Our Ref: PAA/134/18/

8th March 2019

Pre-Application Advice

Erection of 38 No. Apartments
Gas Works Site Ford Road Arundel

4 Car Parking

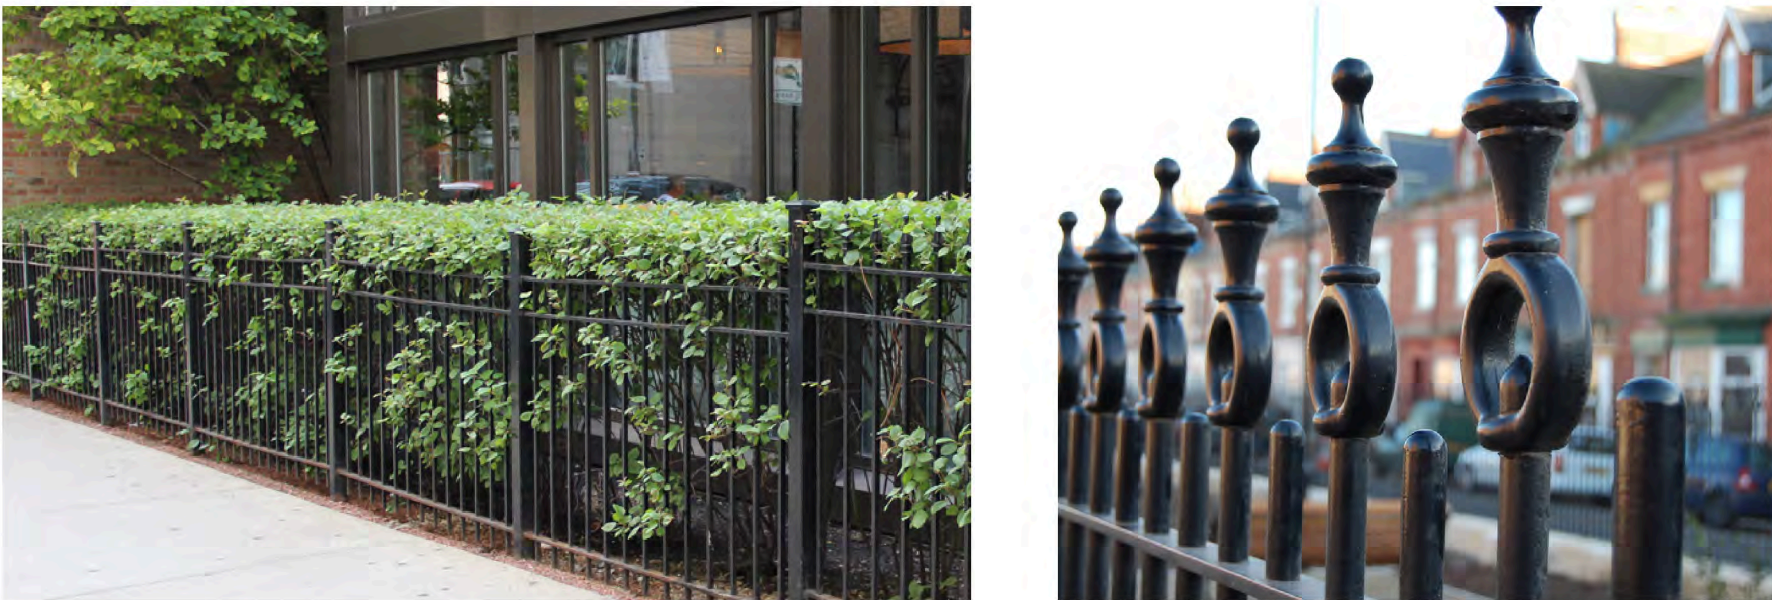
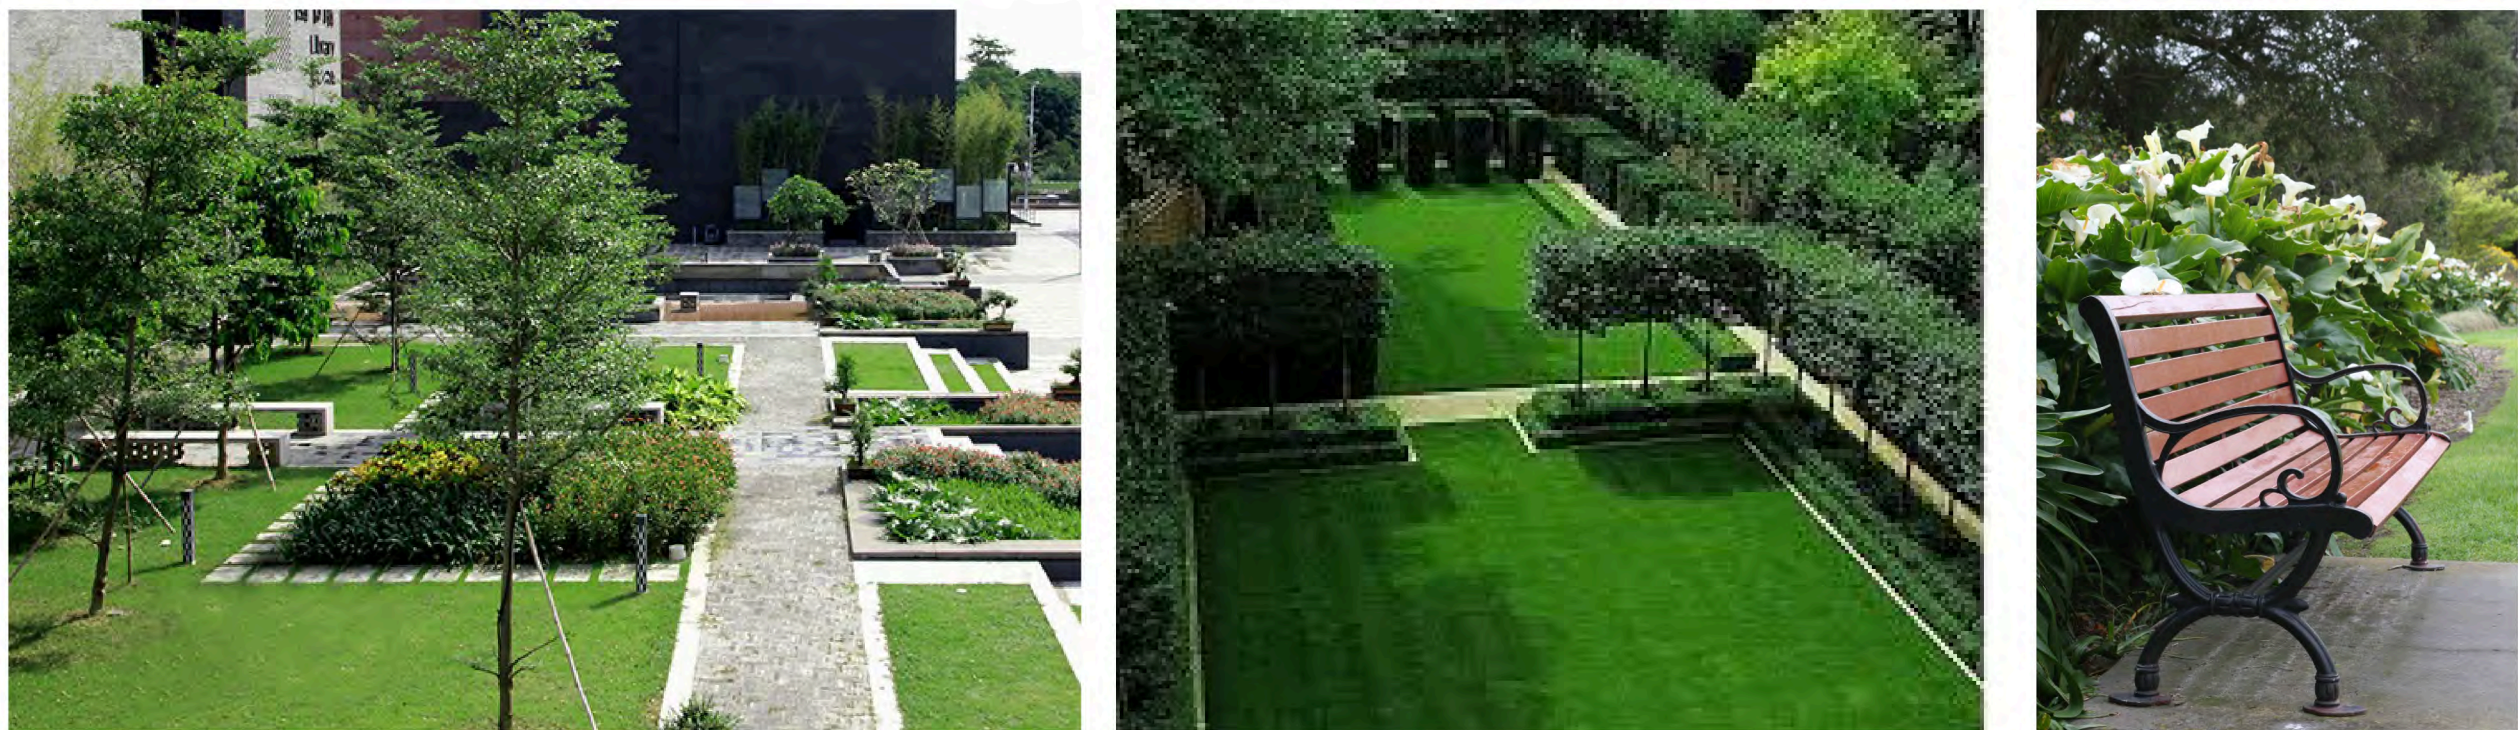
1) Car parking in the rear garden - If possible the preferred outcome to minimise the impact of the development on the neighbouring properties amenity is for the majority of car parking to be located in underground car parking rather than surface car parking as shown on the submitted plans.

The landscaping and boundary treatment to the south western boundary adjacent to 1 Ford Road should be substantial and could be increased in depth as a result of a reduced car parking requirement and the incorporation of underground car parking (see Highways, Transport and Parking para below).

The car port building should be located closest to the boundary with 1 Ford Road with any open areas of car parking located further away from the shared boundary ideally with the car port intervening providing a noise, visual and fumes pollution barrier. The height of the ridge and eaves of the proposed car port should be kept to minimum in this location to avoid an overbearing impact and/or loss of daylight to the rear garden of 1 Ford Road.

UPPER GROUND FLOOR PLANS

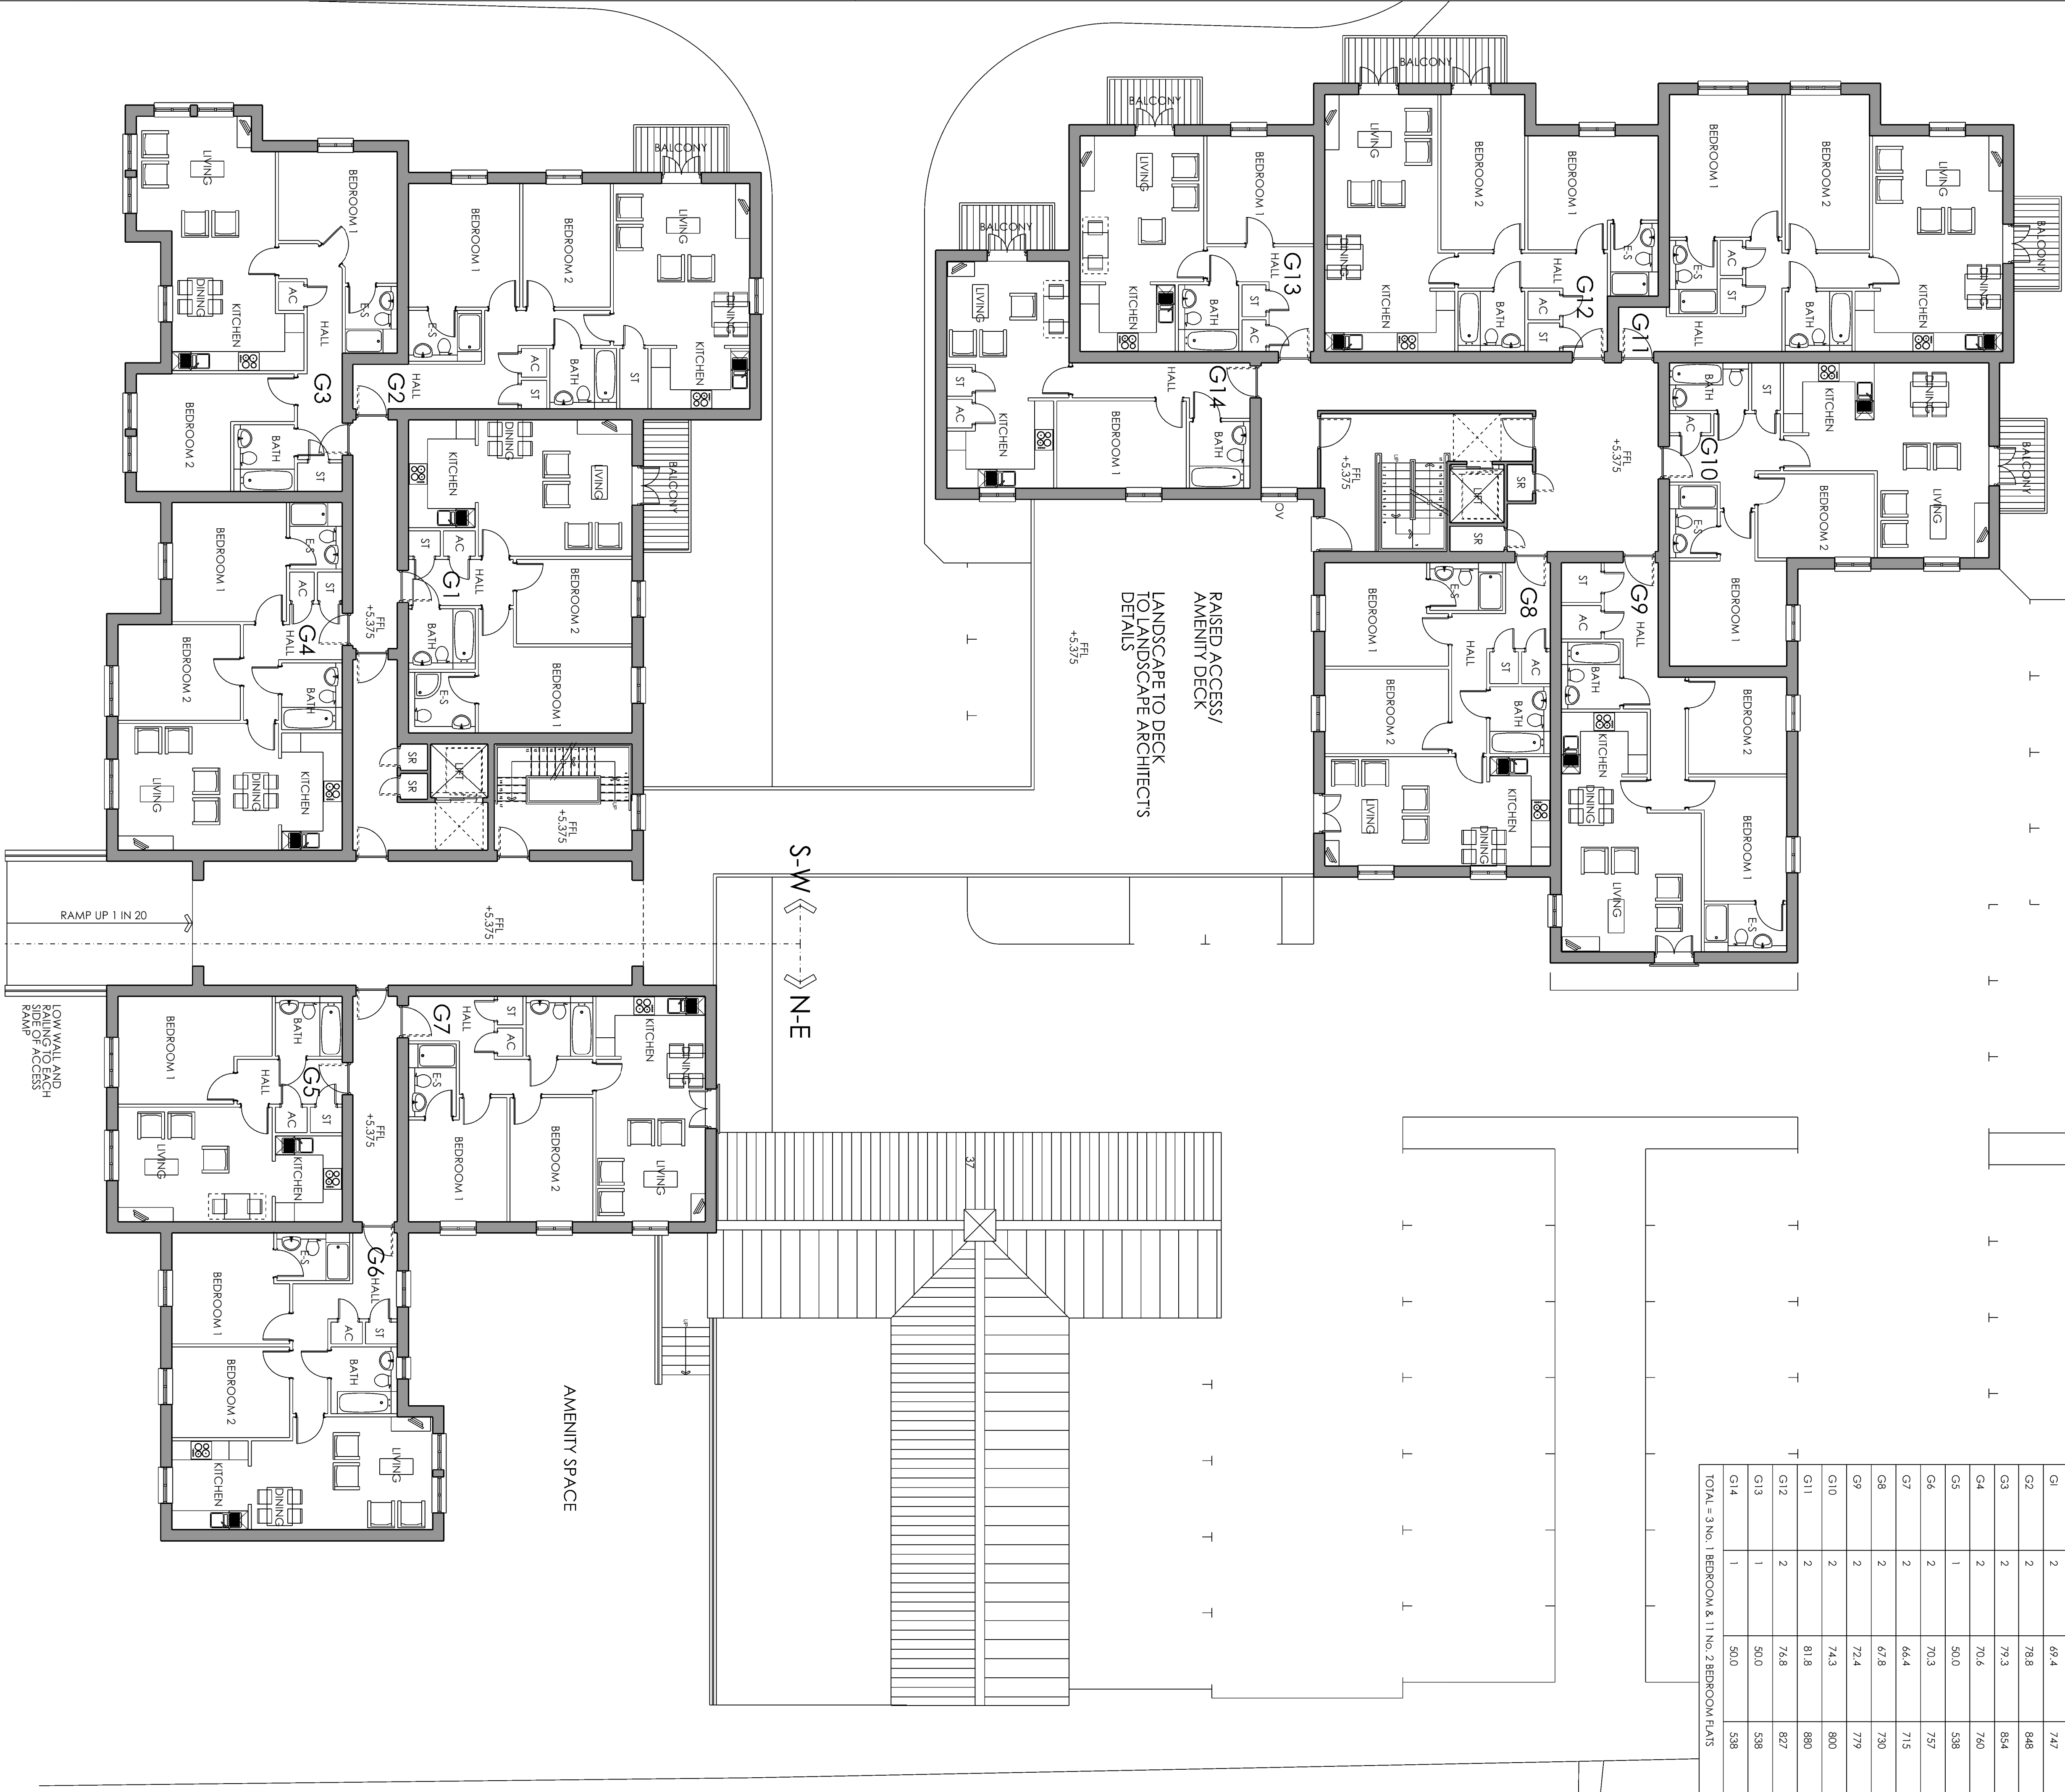
Legibility - There is an opportunity to make a higher corner feature at the north eastern corner of the site which would improve the legibility of the development as the first built form on the southern side of Ford Road on leaving or approaching the town centre of Arundel .

Flat roof dormers - The use of flat roofed dormers is not considered in character with the local area in the context of the Victorian dwellings nearby. It is advised that pitched roof dormers are used throughout the scheme.

Balconies - The use of external boundaries on the north east elevation facing the A27 and the south east elevations facing the river would be appropriate however this would not apply to the north west elevation on Ford Road due to the character of the street scene and the south west elevation due to amenity considerations as the balconies could potentially have an overbearing impact on the rear gardens of family houses on the southern side of Ford Road.

2) The south west facing windows in block A closet to 1 Ford Road particularly at first and second storey level facing the side elevation of 1 Ford Road should ideally be moved to the front and rear elevations of the building as it is noted that there is a velux window in the roof directly facing the side elevation of block A at a distance of approx. 12 metres.
